Our Ref: LU/242/19/HH
Your Ref:

Town & Country Planning Act 1990 (as amended)
Town & Country Planning (Development Management Procedure) (England) Order 2015
Application for Planning Permission for Works or Extension to a Dwelling

Development Extensions to front and rear. Change of external finishes.
Location 5 Reef Close Littlehampton

Drawing:
Ground floor

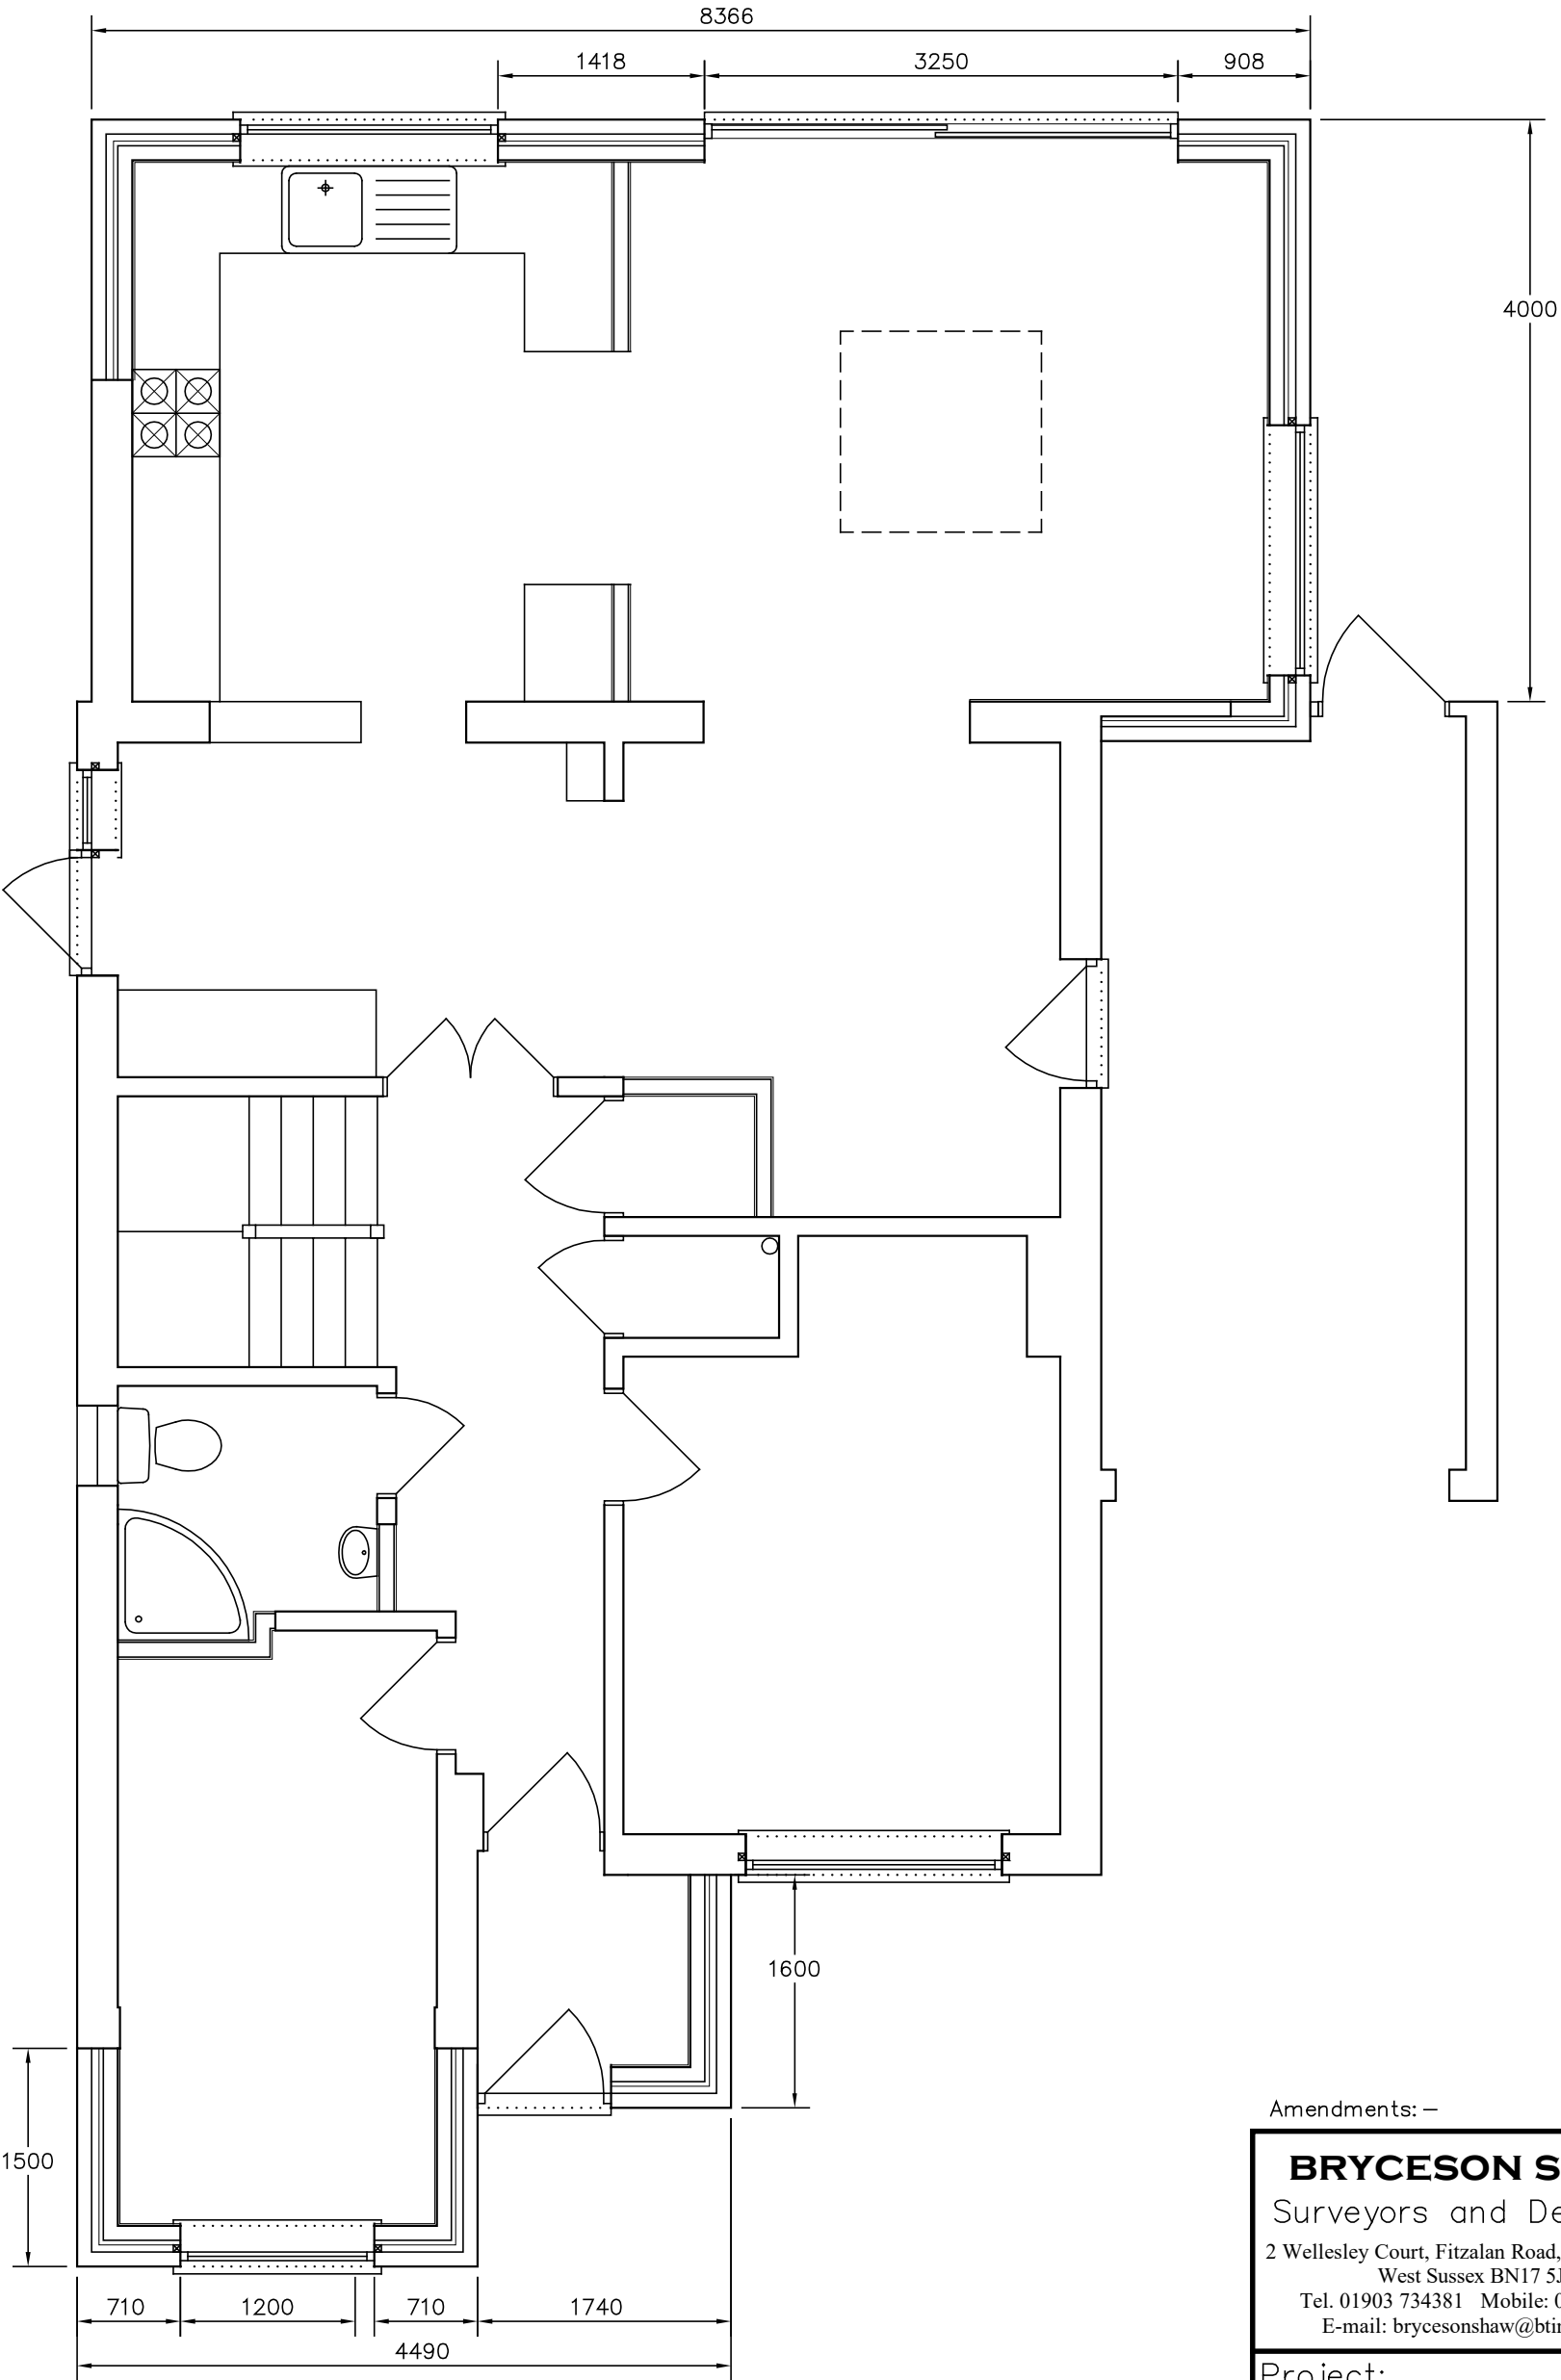
Room Labels: Please include room labels on the proposed floor plans.

Drawing:
Elevations as proposed, block plan and roof plans

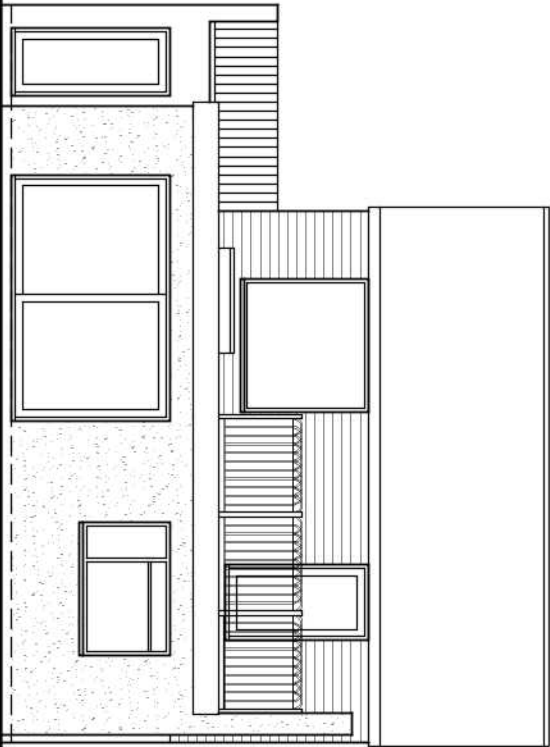
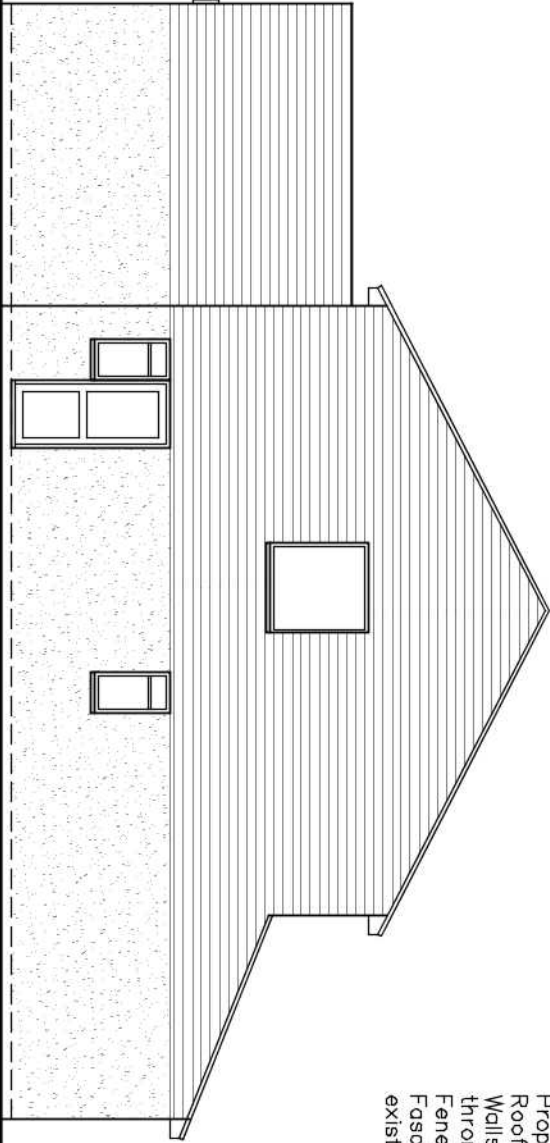
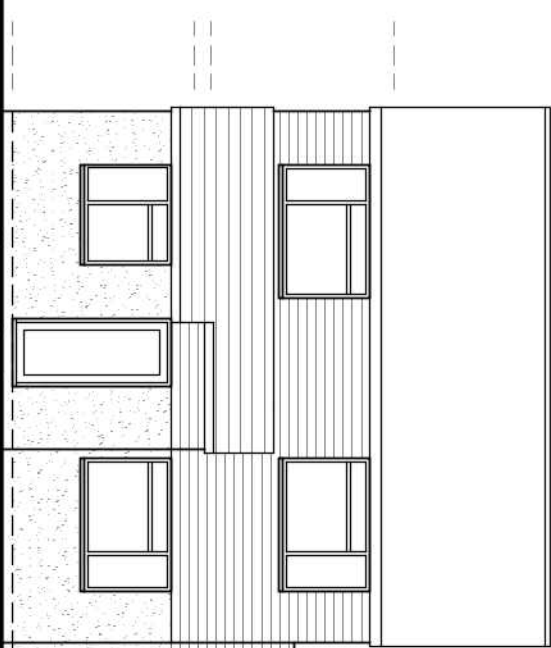
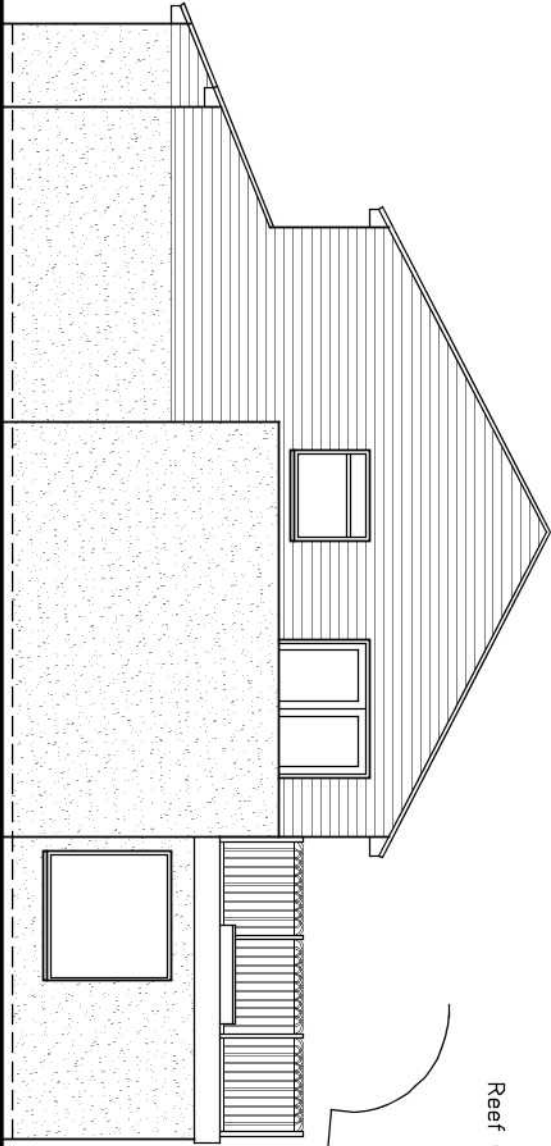
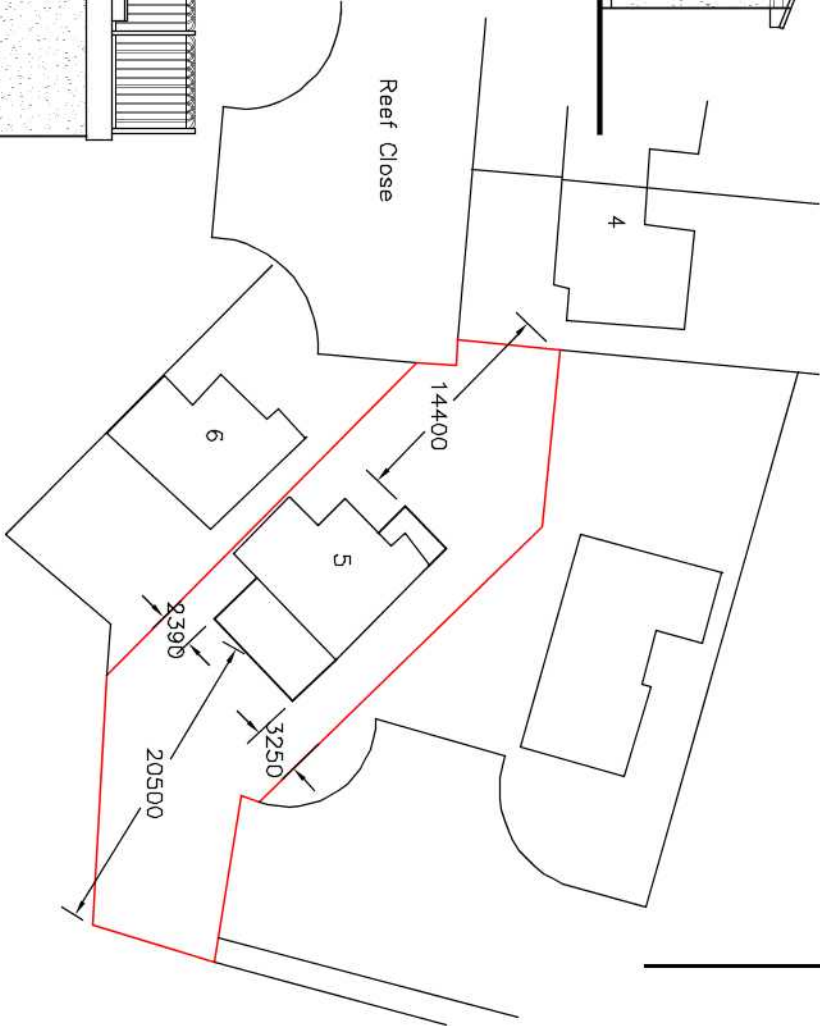
Balcony: Please confirm whether you are proposing a balcony with this application if so it will need to be included in your description. With your permission we can add it to your description.
